**RE: PPR-18-026 New Widefield PK-8 School  
First Submittal**

Please see below for response (*in blue italics*) to **PCD-Engineering Review Comments** for the above referenced project, dated July 9, 2018. Responses include input from project design engineers and consultants as follows: Drexel, Barrell & Co. for civil; William Guman & Associates for landscaping; LSC Transportation Consultants, Inc. for traffic.

LS2.0

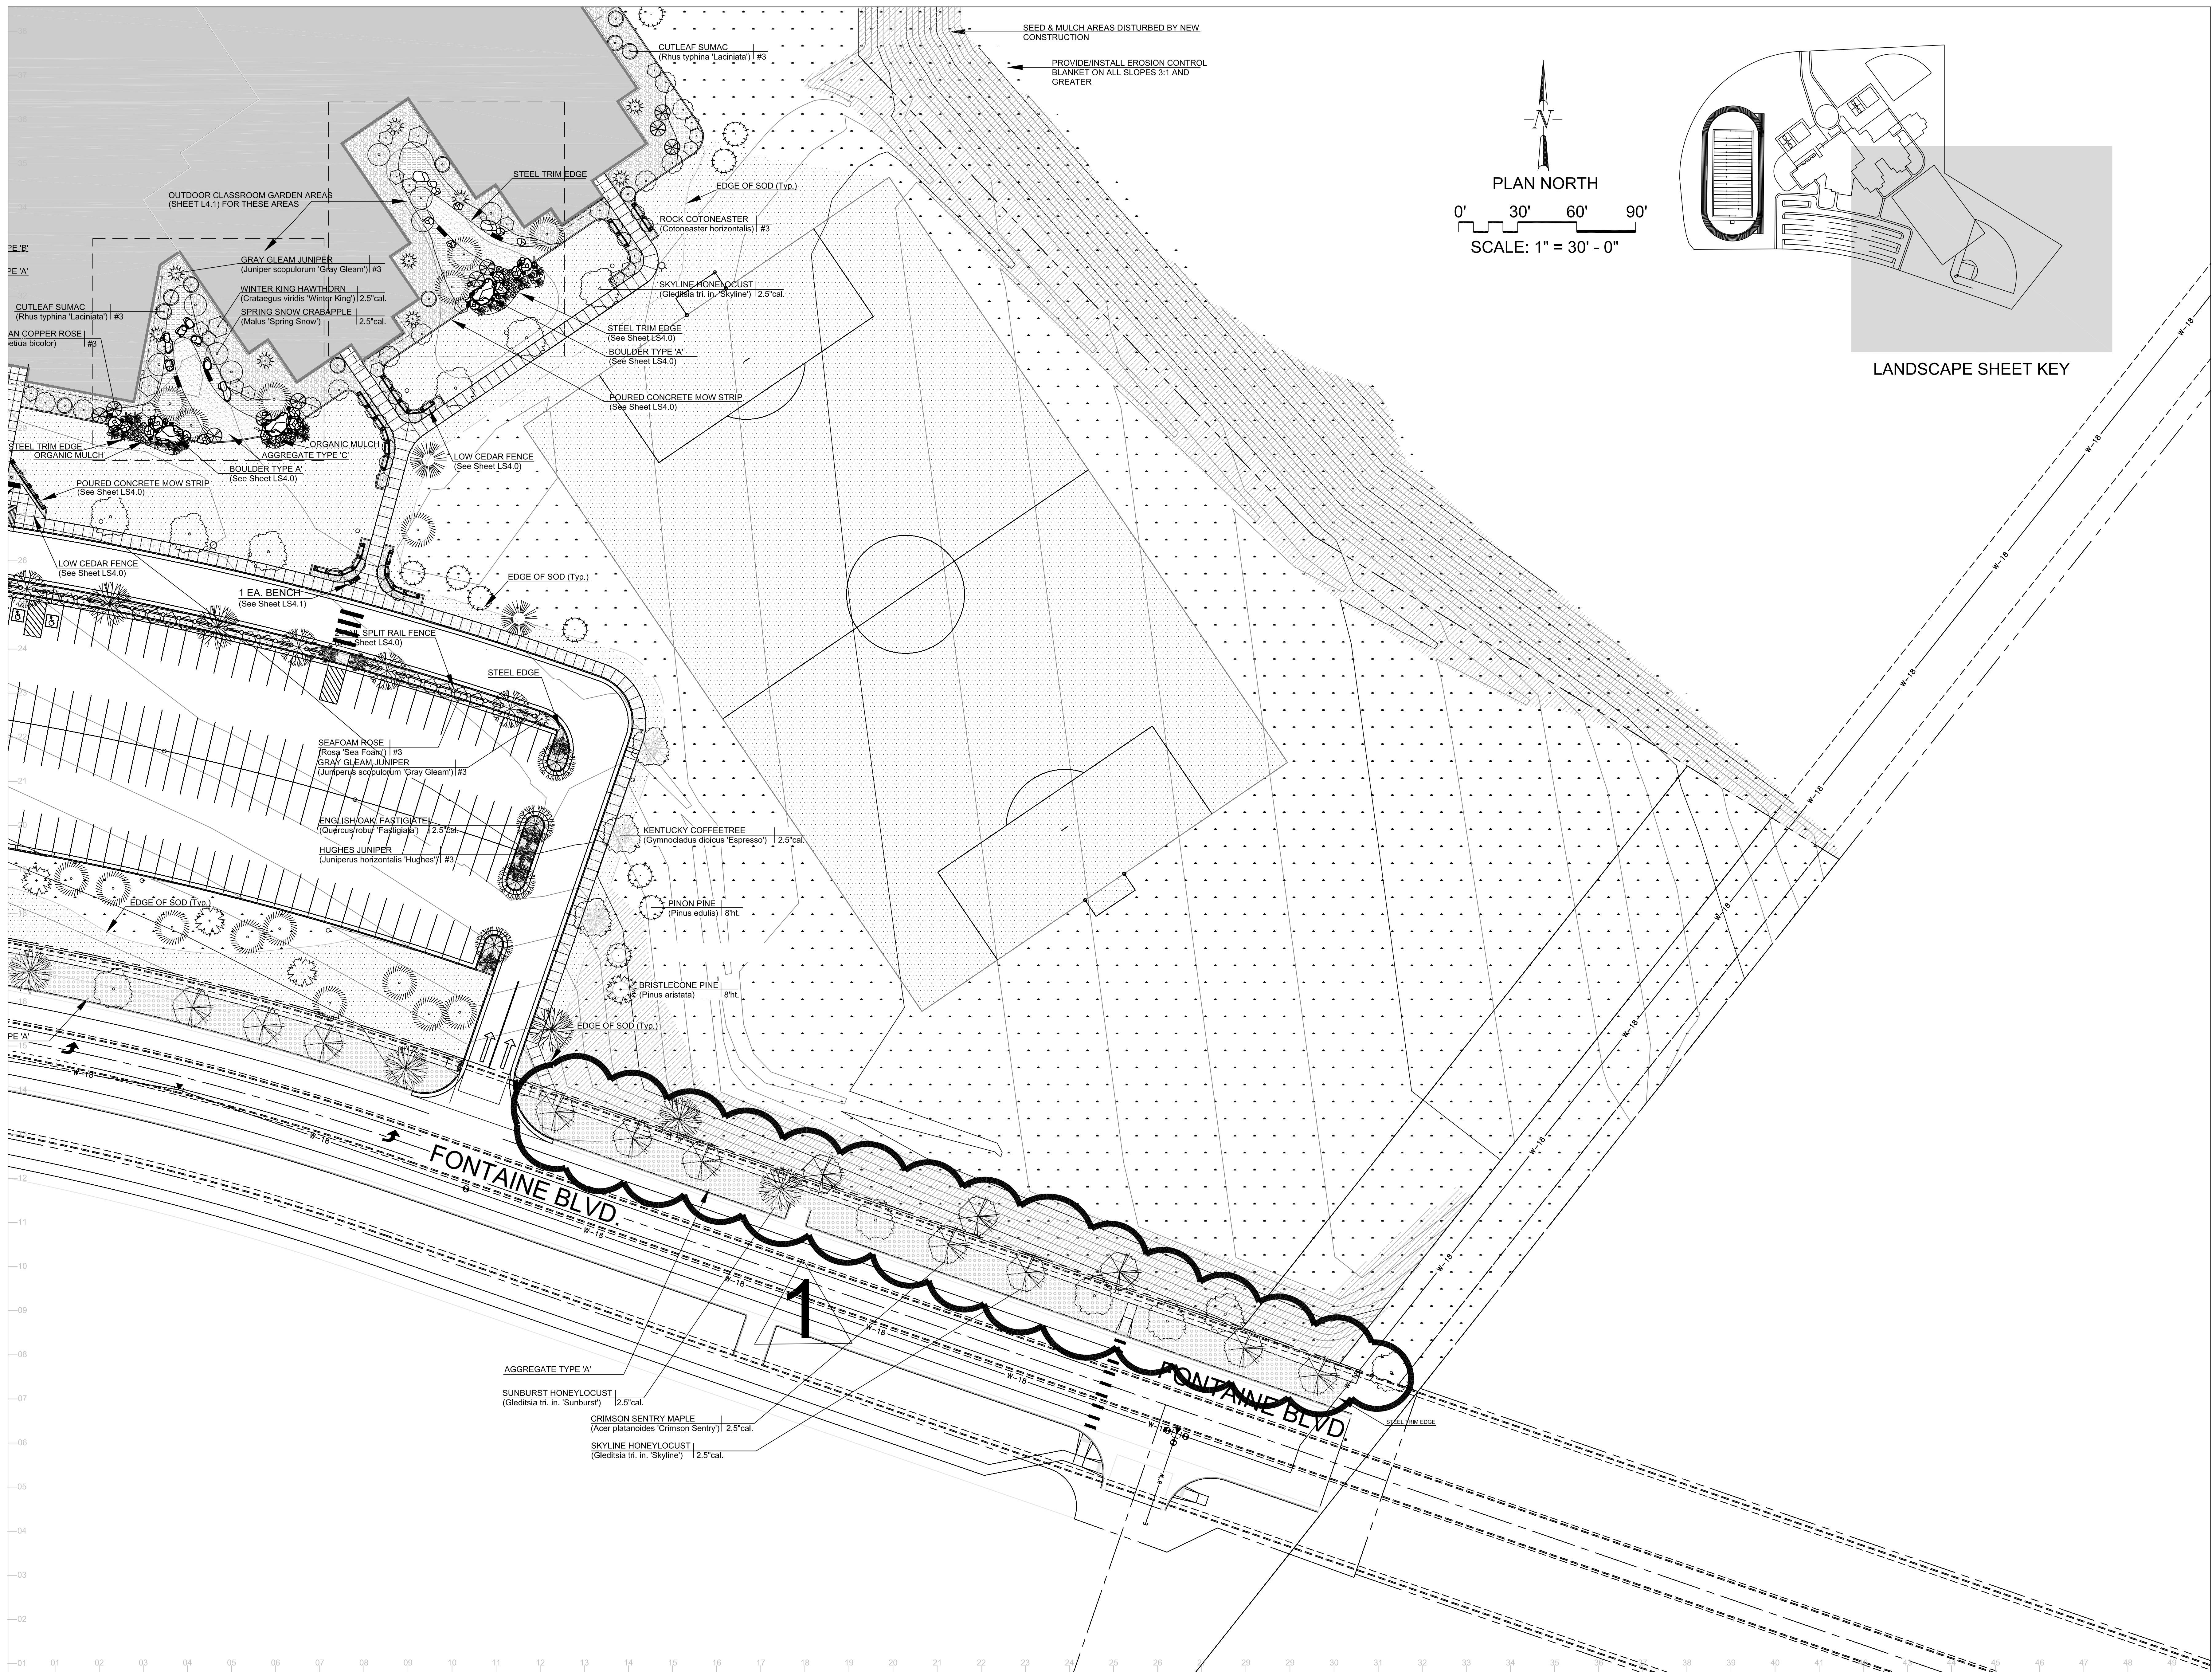
- d. LANDSCAPE PLAN COMMENT: Make sure trees do not cause too much debris in the right of way. – license agreement with county engineer. **RESPONSE: Trees along Lamprey Dr. are relocated away from right of way. See LS2.0 & LS4.0.**

2. The proposed landscaping along Lamprey Drive needs to be adjusted. Typically the required landscape strip needs to be 8 feet between the curb and sidewalk to allow for trees in the County right-of-way. Possible adjustments could include meandering sidewalk, shifting the sidewalk 4 feet back, or moving trees behind the sidewalk. **RESPONSE: PUD Development Guidelines show street section for Lamprey Drive with 4' between back of curb and sidewalk. The sidewalk design and construction are by the developer. The trees along Lamprey Dr. are**

**relocated to the opposite site of the sidewalk. See LS2.0 & LS4.0.**

LS4.0

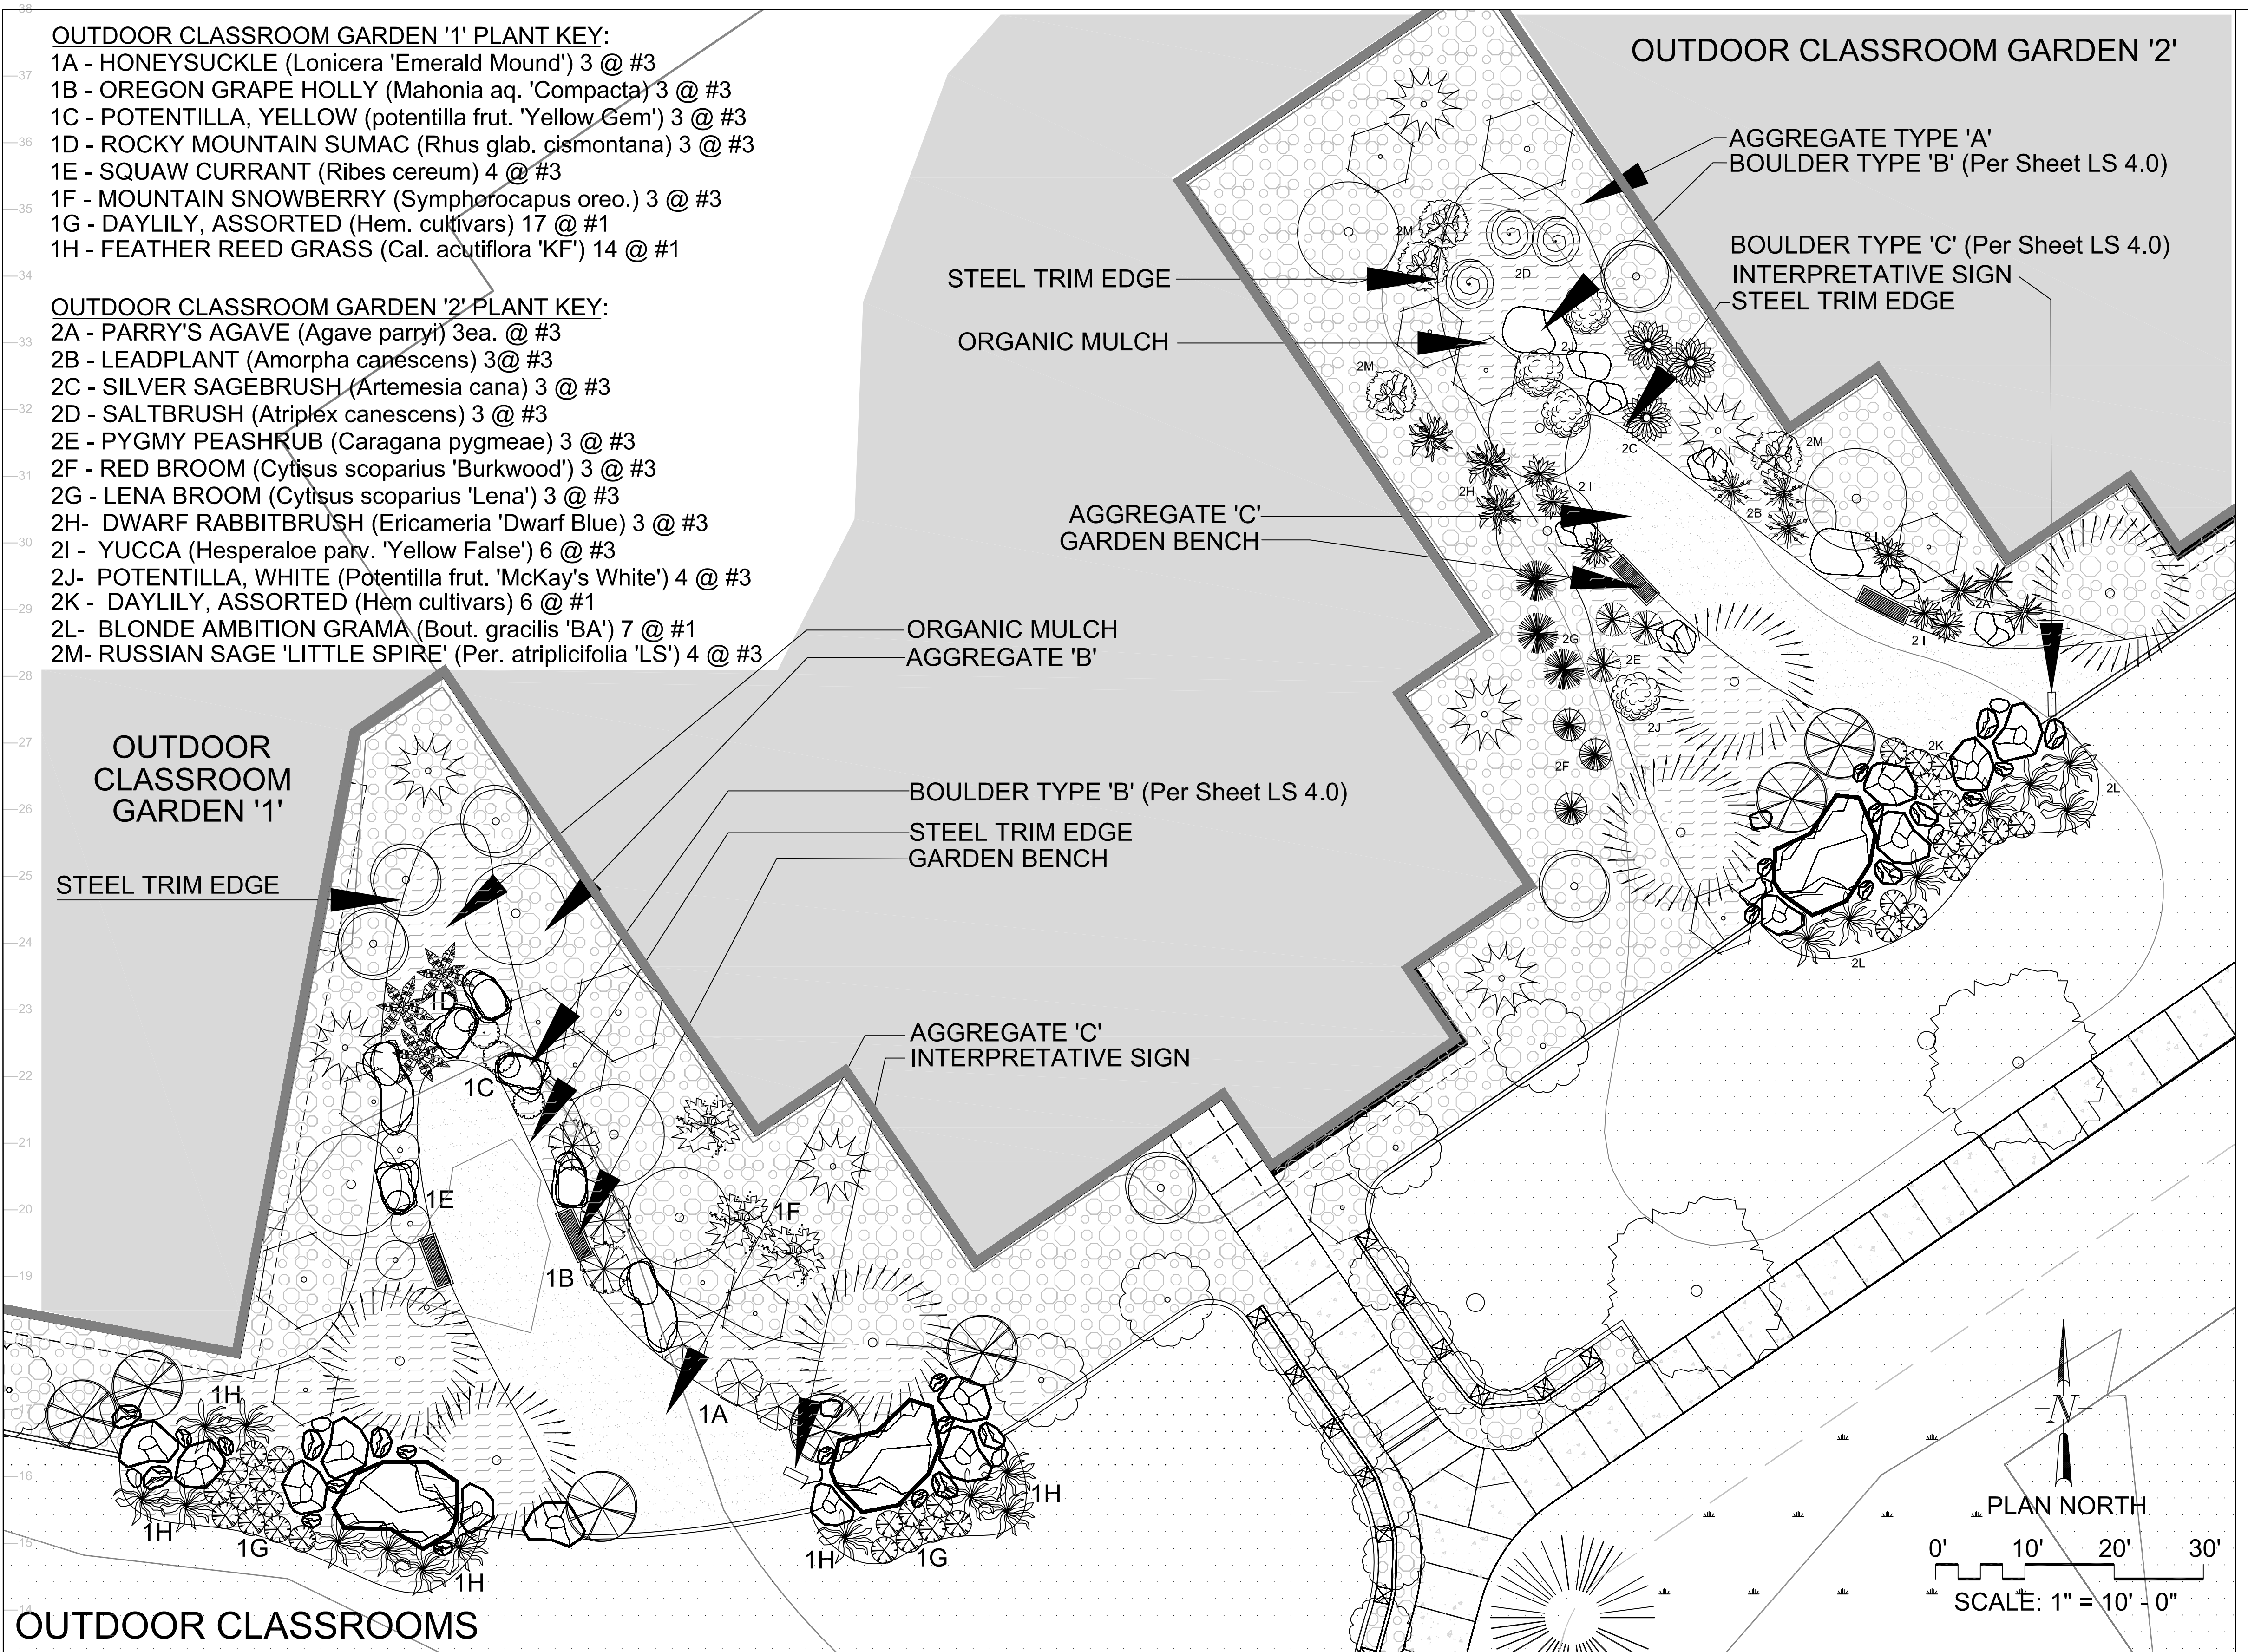
- c. LANDSCAPE PLAN COMMENT: Include a table of how many trees are required and provided per the PUD guidelines that were attached in another comment. **RESPONSE: All minimum landscape planting requirements have been met (and/or exceeded). See Letter of Intent and sheet LS4.0.**
